Our ref: SSD-65924461

22 April 2025

Subject: Stephen Road Multi-level Warehouse, Banksmeadow - Additional Matters for Submissions Report

Department's Request for Information

3 SHADOW DIAGRAM - SUMMER SOLSTICE - 3pm 1 : 1500

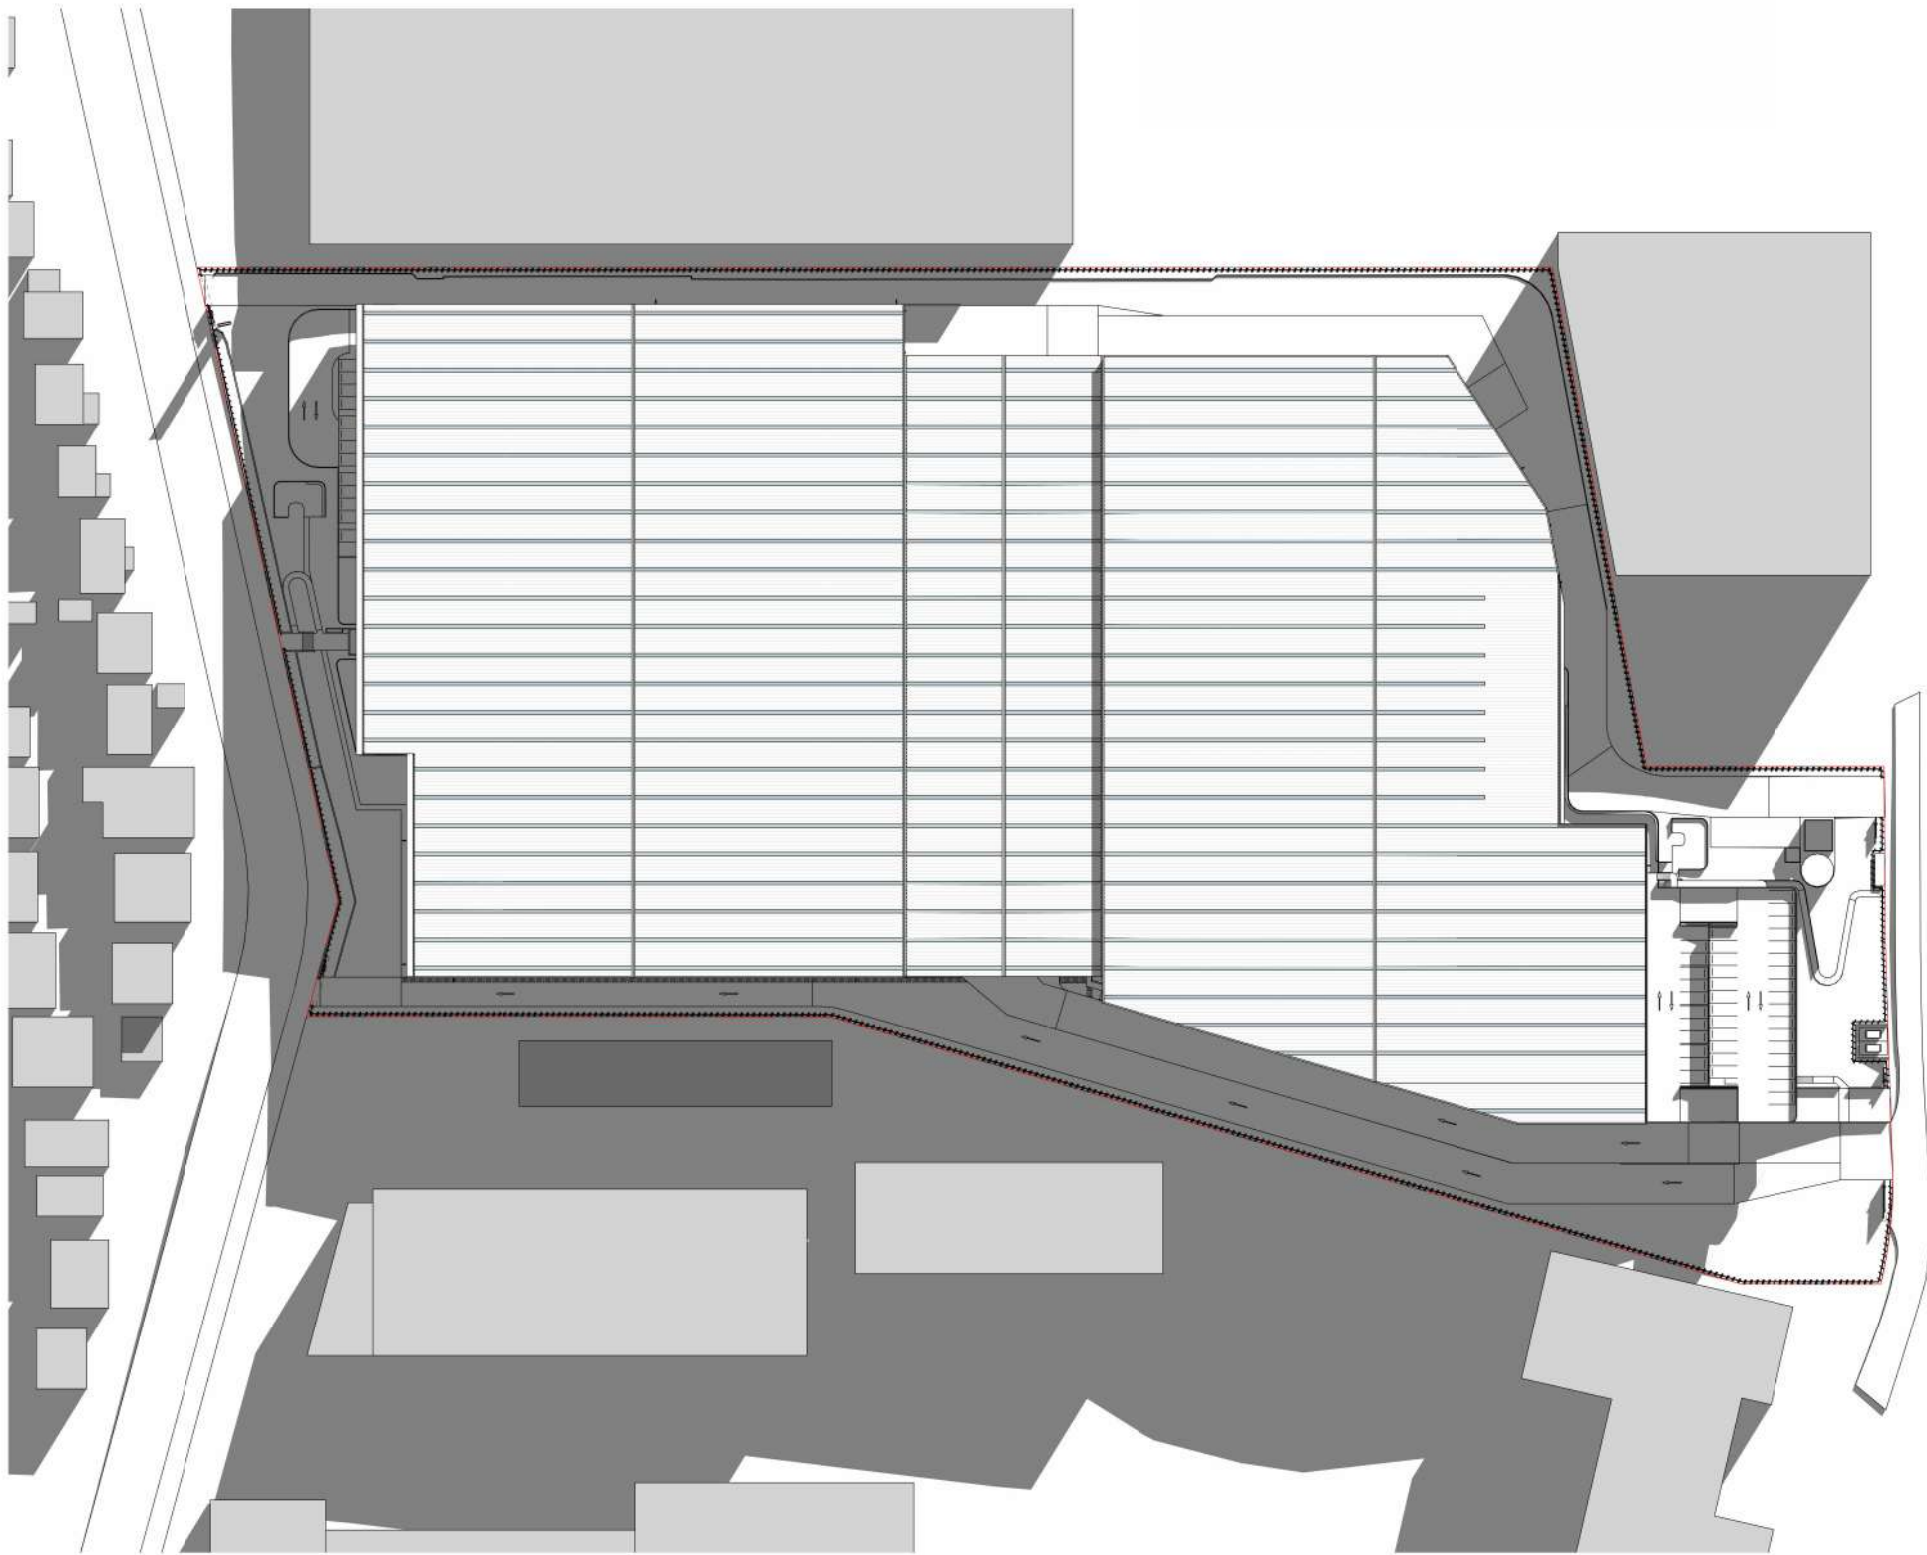
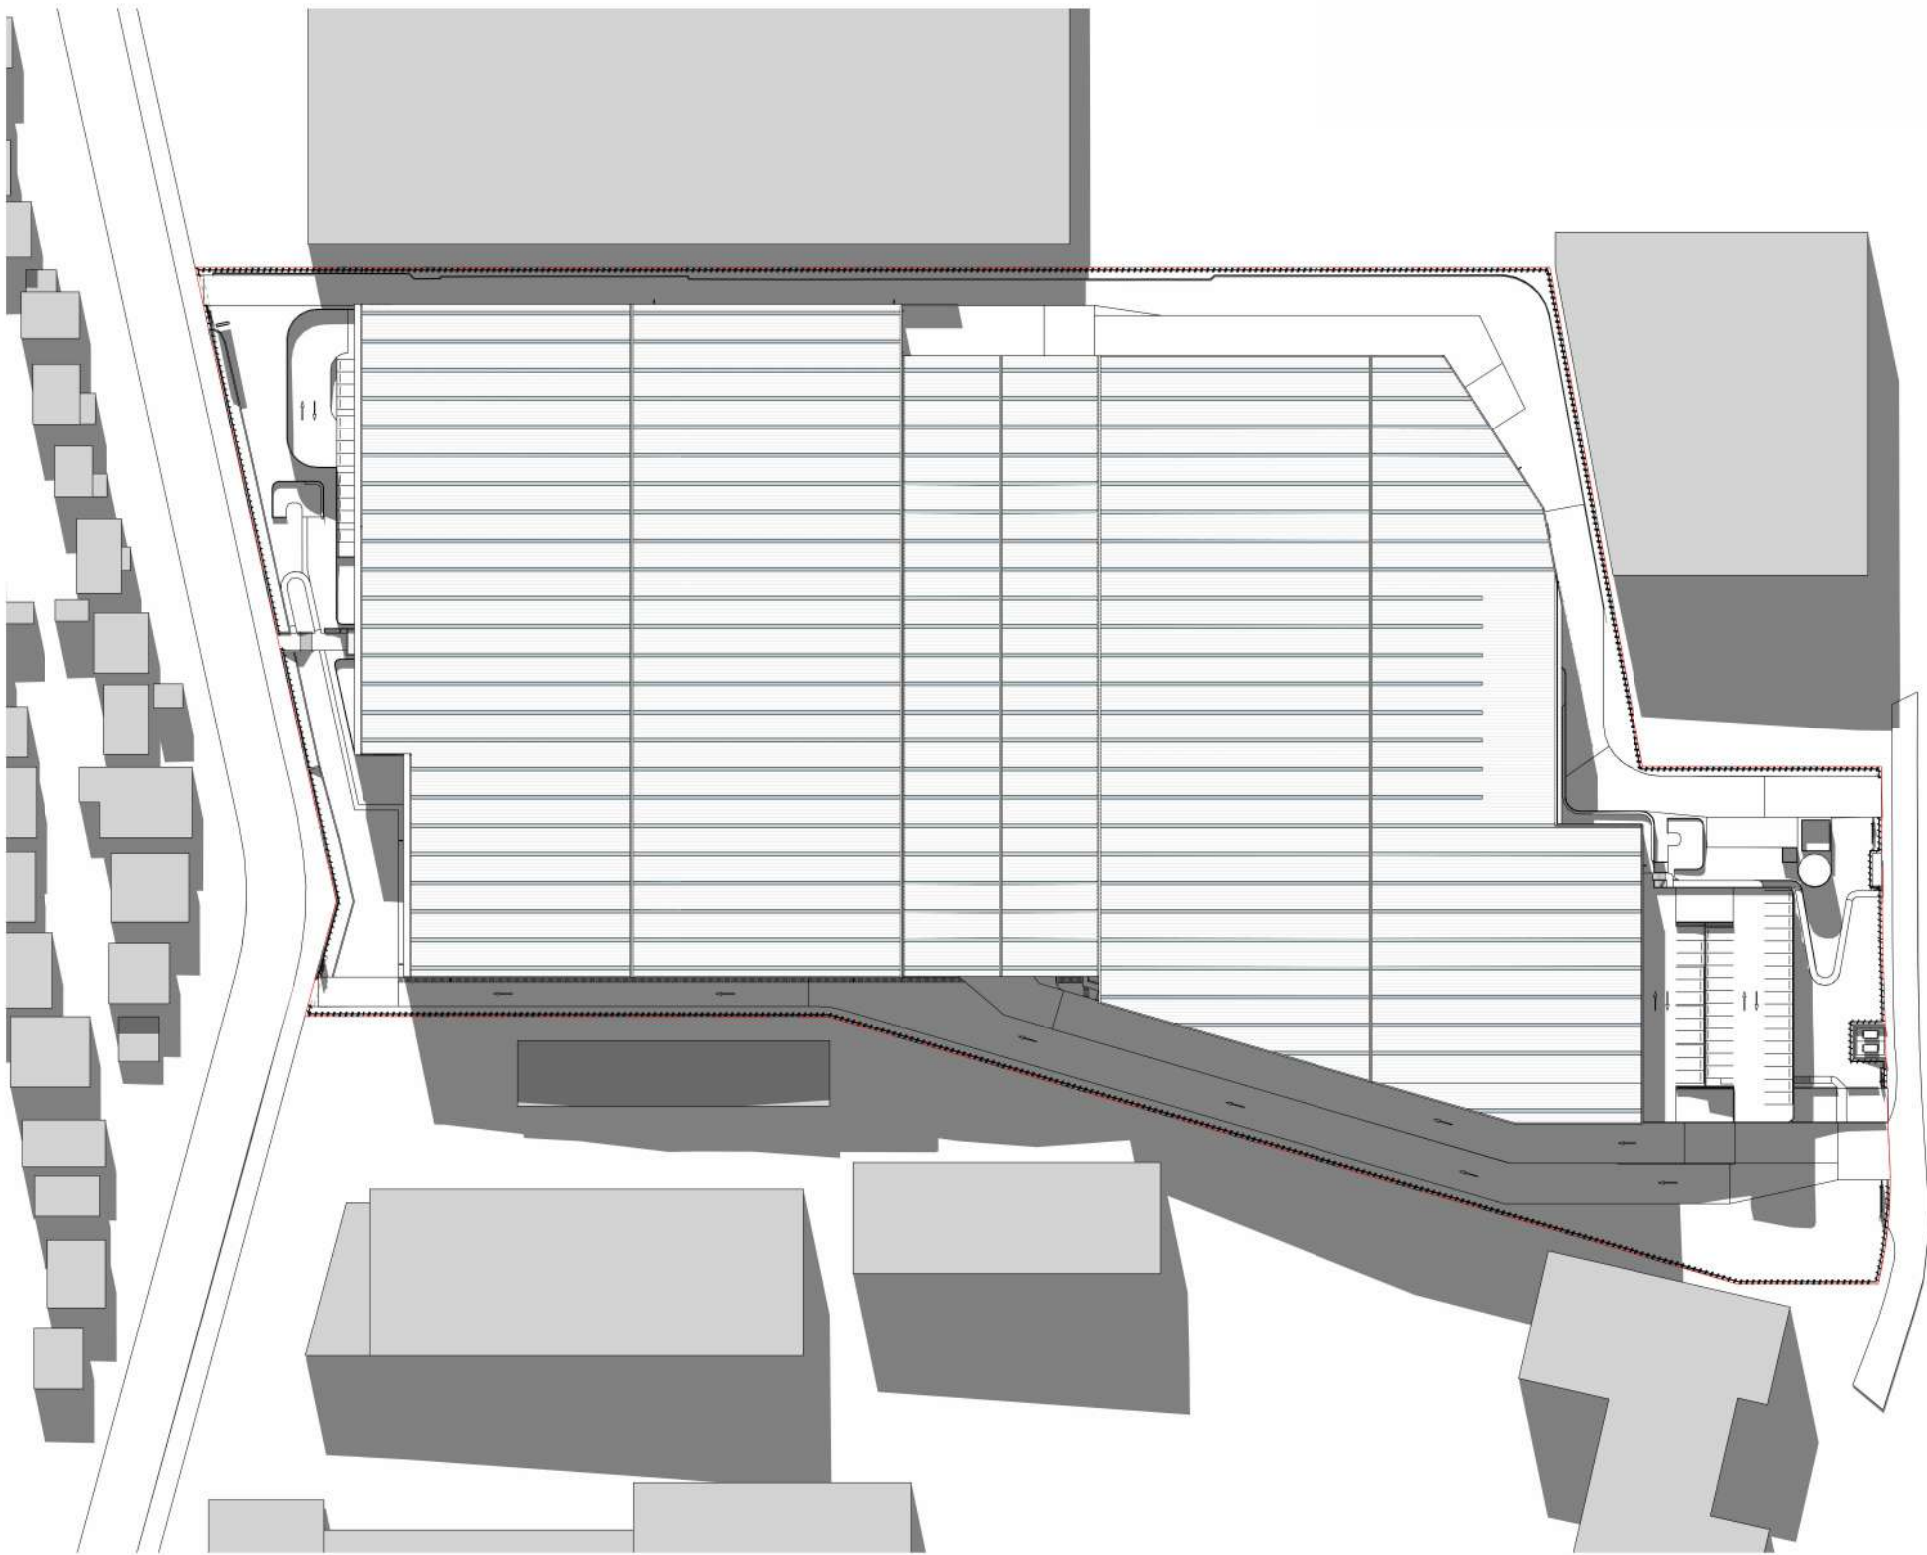
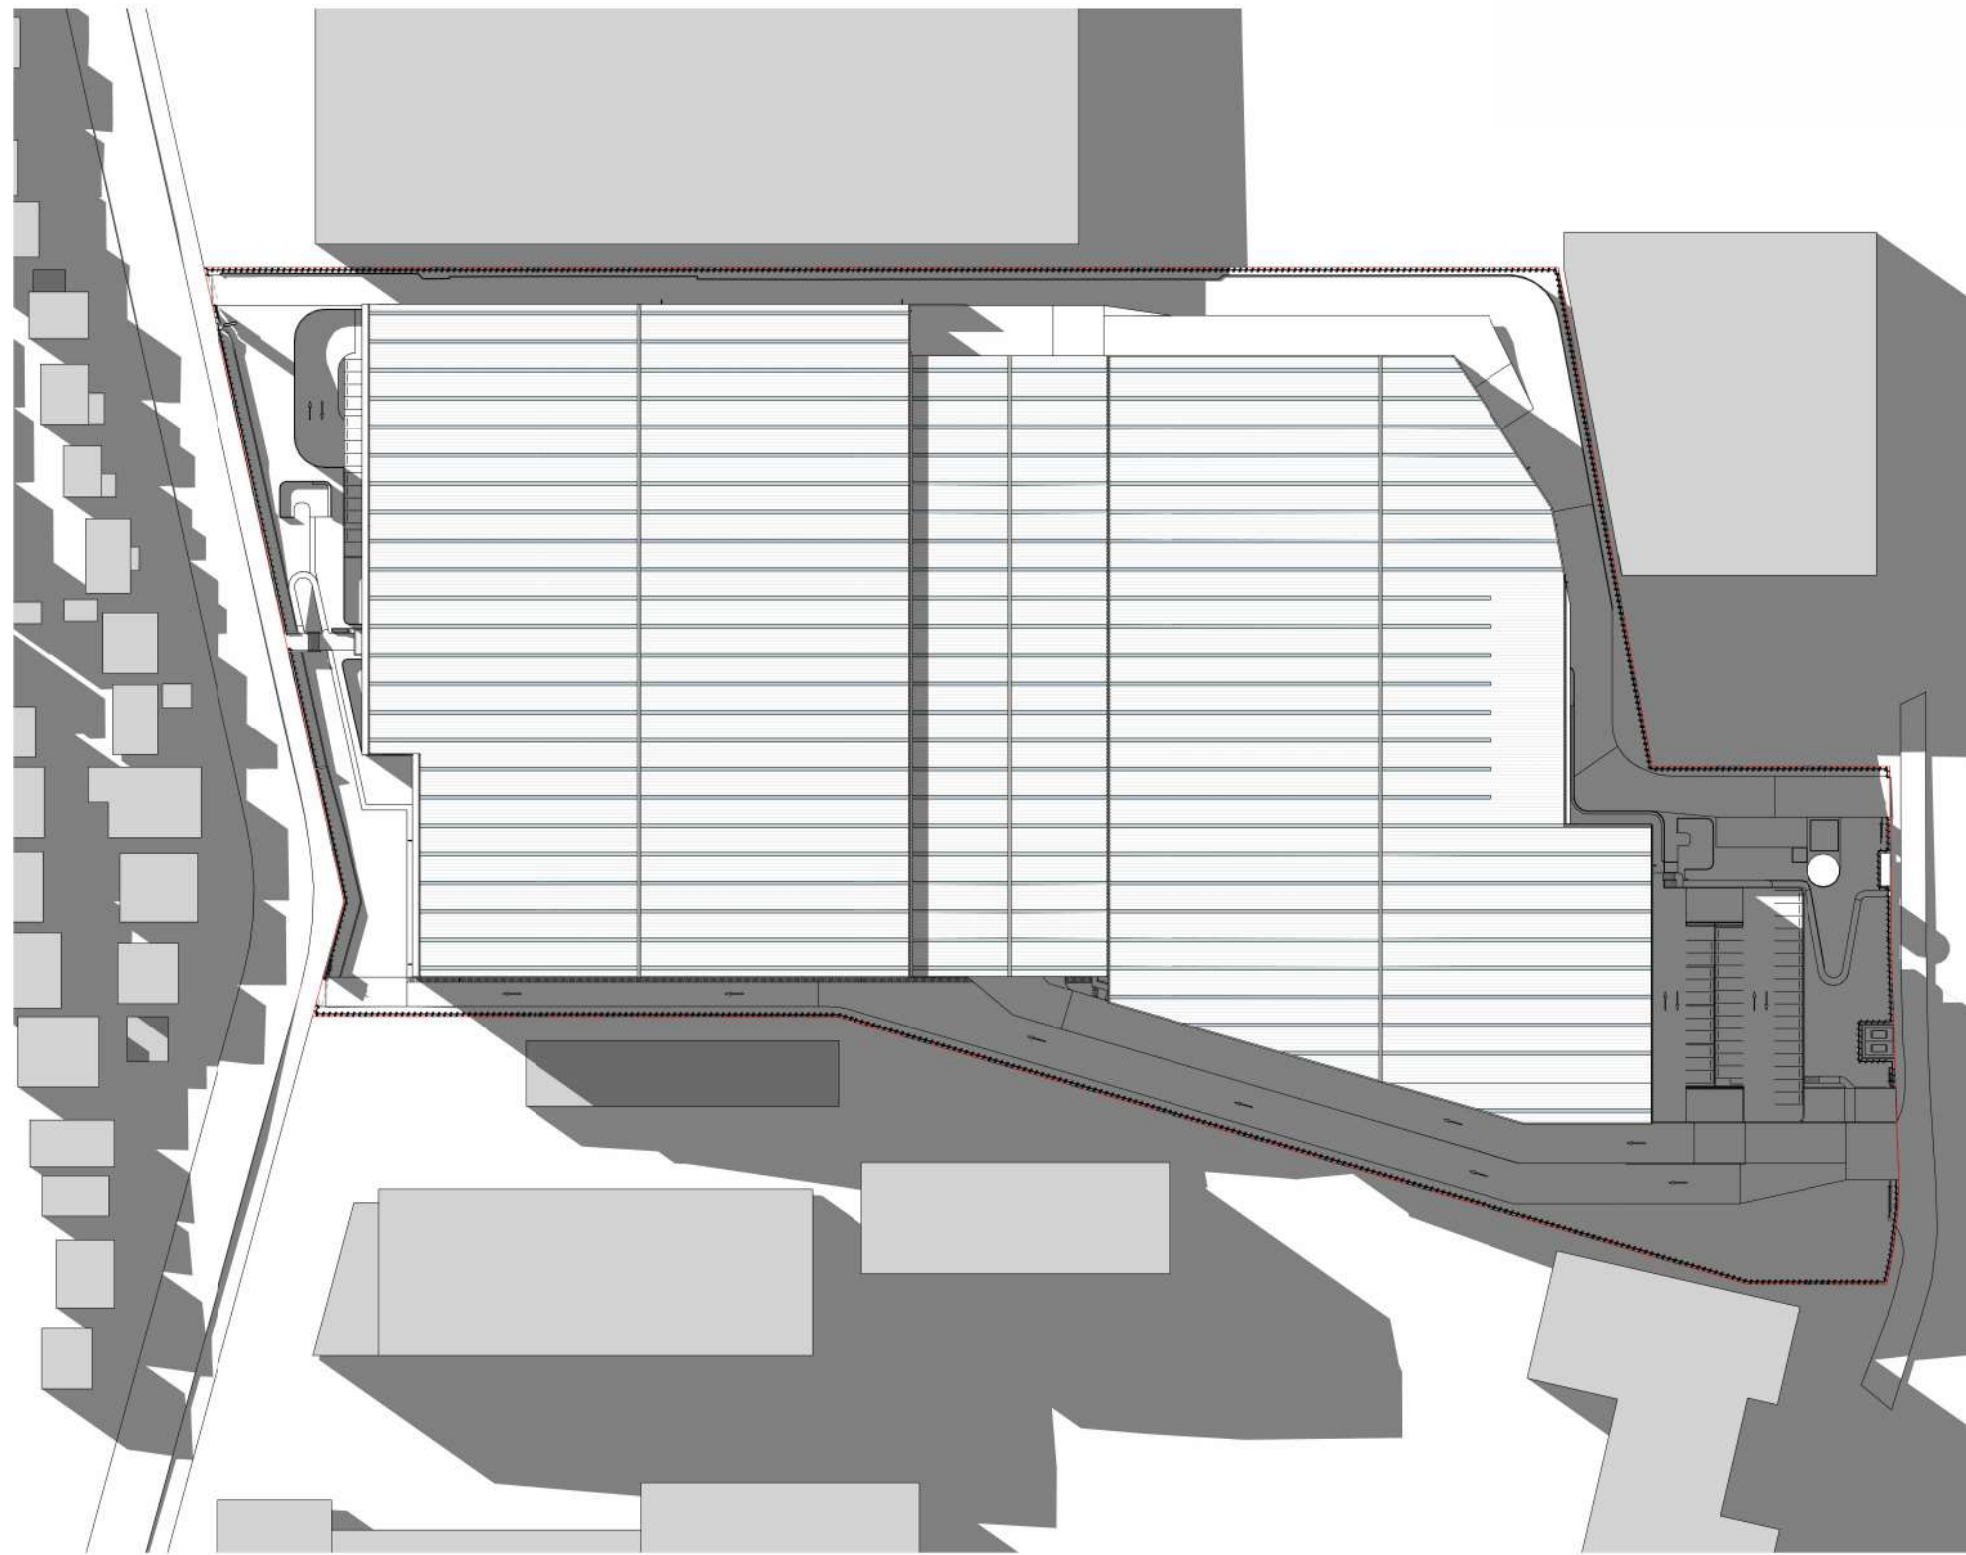
4. The Department raises concerns over the shadowing impact the proposal will have on residential properties opposite the site on Stephen Road, particularly during winter mornings. Revising the buildings interface with Stephen Road by reducing the scale of the building will likely assist in minimising the impact on solar access to the sensitive receivers.
